RFI

RFI #: 189
Date: 9/18/2012
Job: EB-02 Keller Springs Lofts
Phone: 877-777-5115

Subject: Dimensions on sheets 3.5A & 3.5B

SHEET NUMBER  
**3.5A**  
 BLDG PLAN 'A'

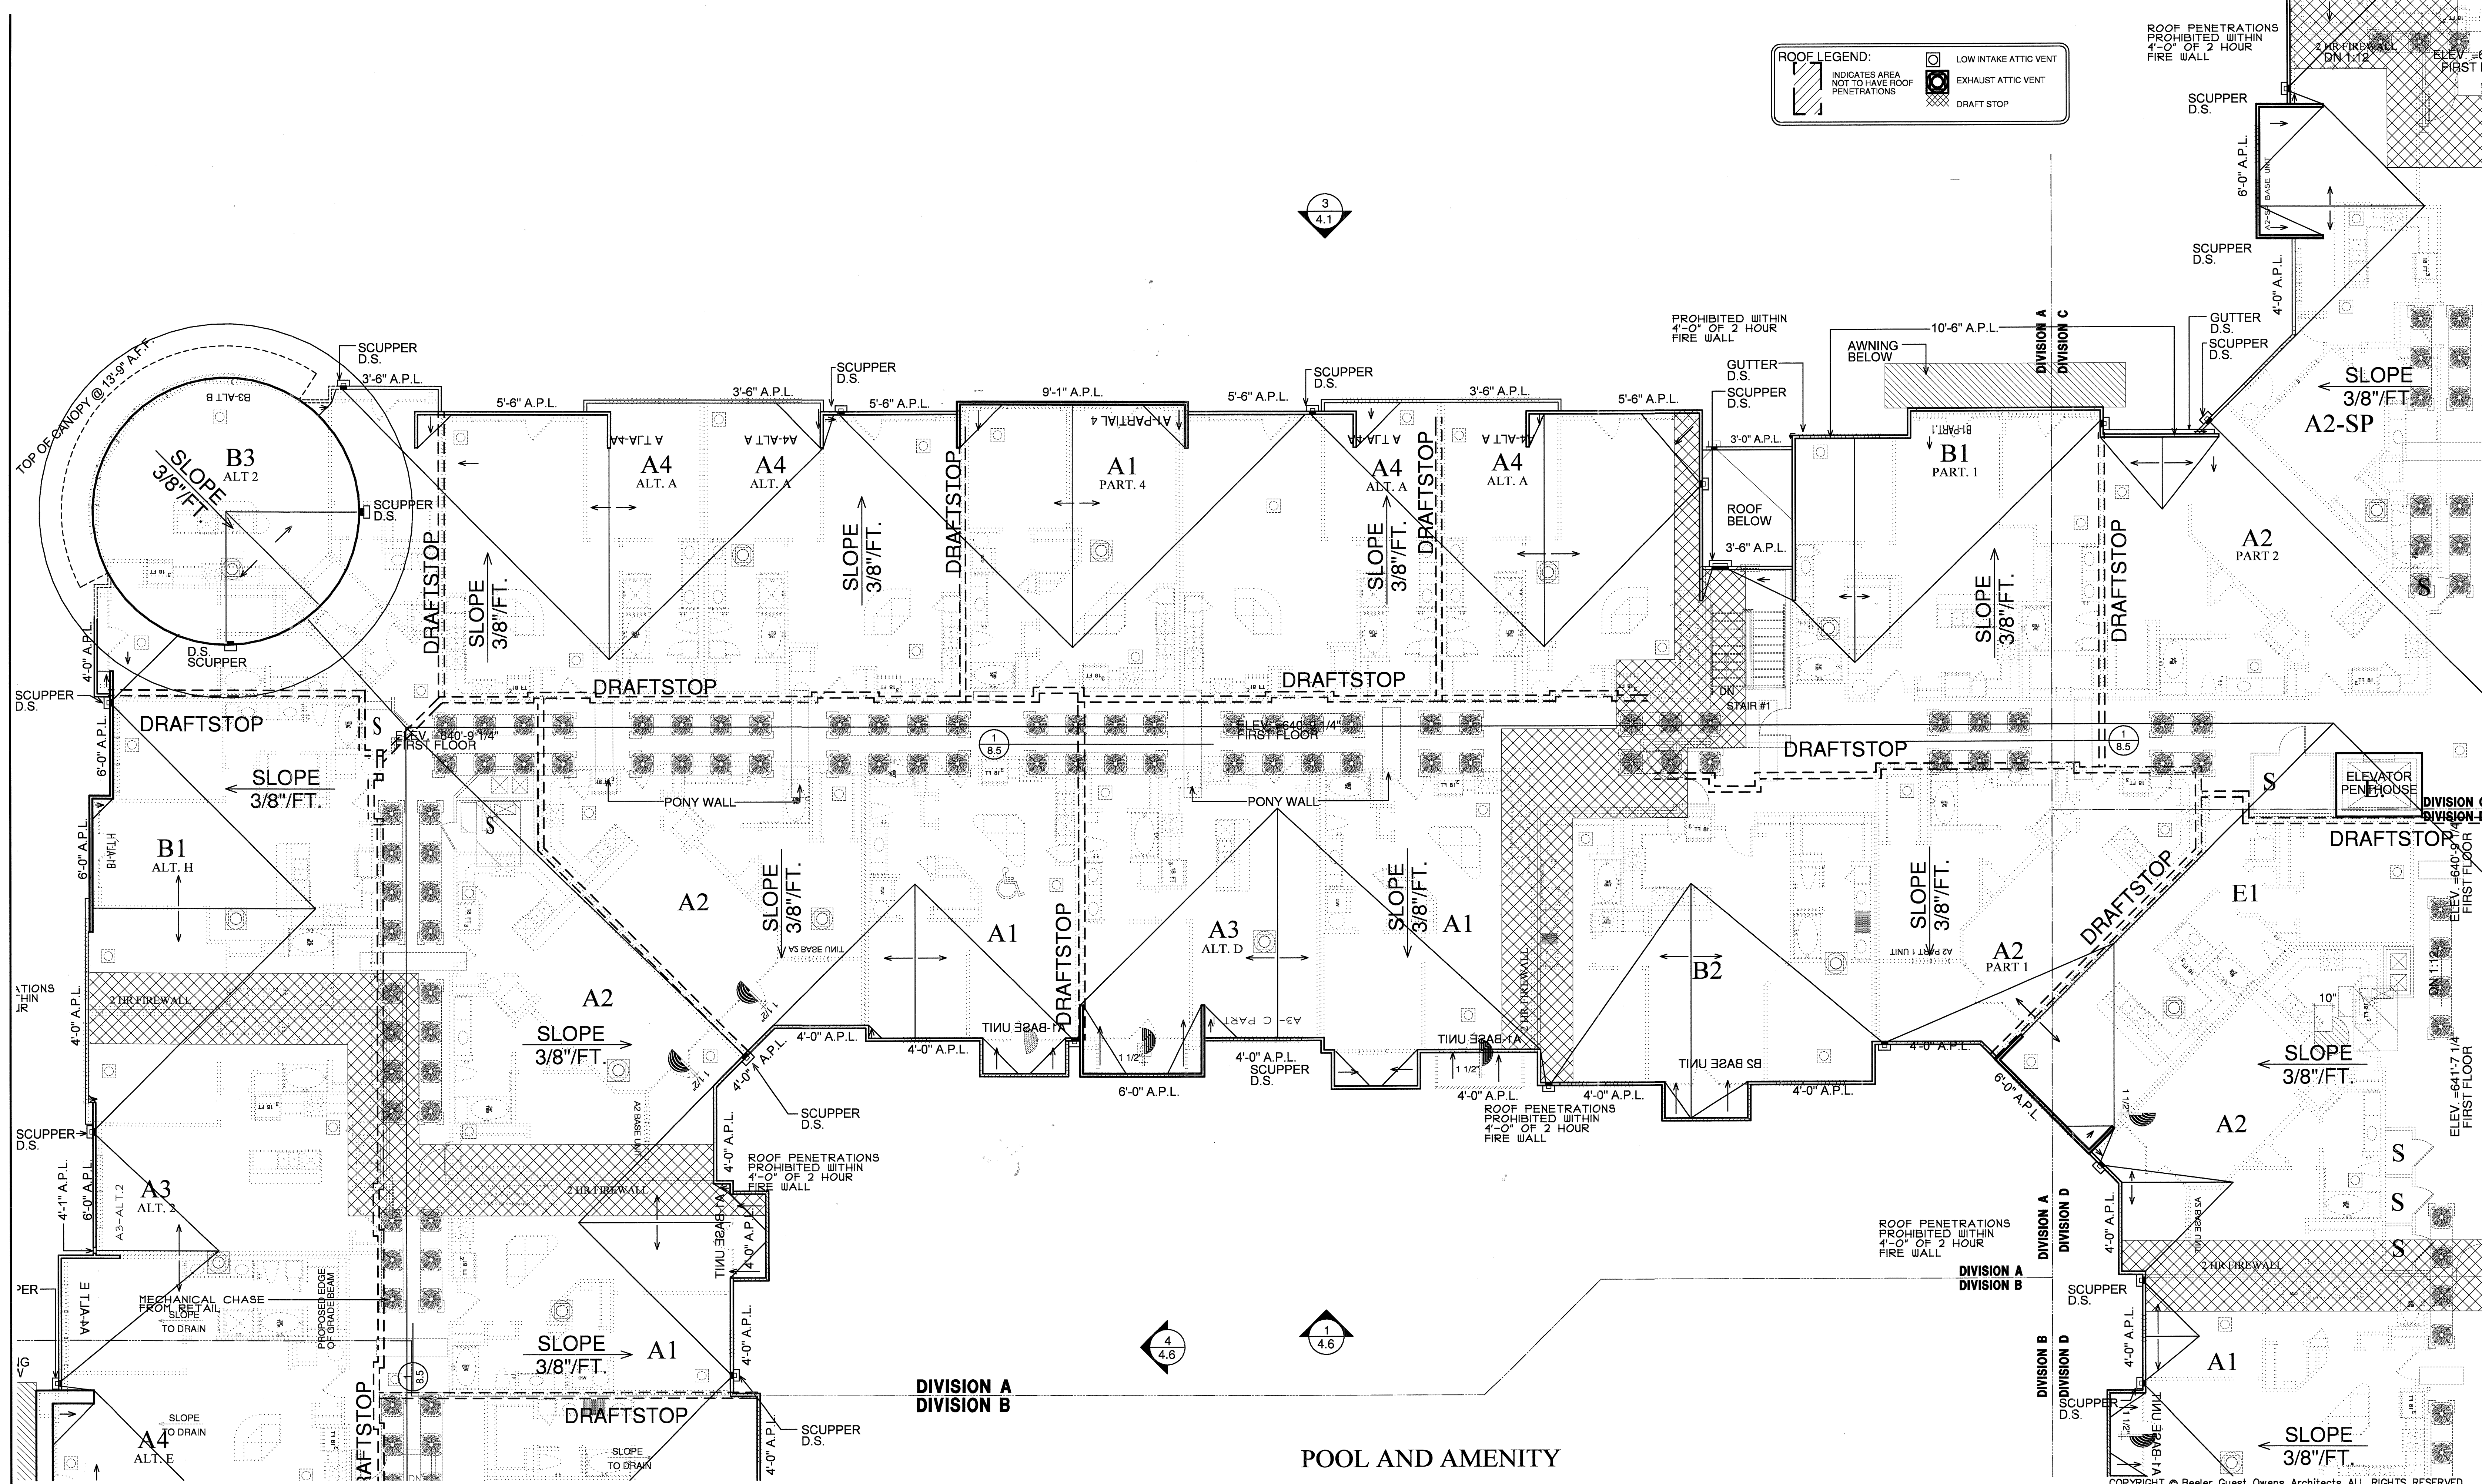
Request: **Date Required:** 9/25/2012
On the roof plan 3.5A at exterior parapet wall at the A3 All.2 unit there is a small area showing 4'- 1" A.P.L. next to the 6'- 0" A.P.L. this same thing happens on the next sheet 3.5B in similar location. What and why is this needed? It is not shown on the building elevation on 2/4.1 or 2/4.3

Response:
These little "cut outs" in the parapet are part of the old design that were not taken out updated similar to the "MECHANICAL CHASE FROM RETAIL" callouts that are not accurate anymore on the roof plans. SK-10 has fixed all of these.
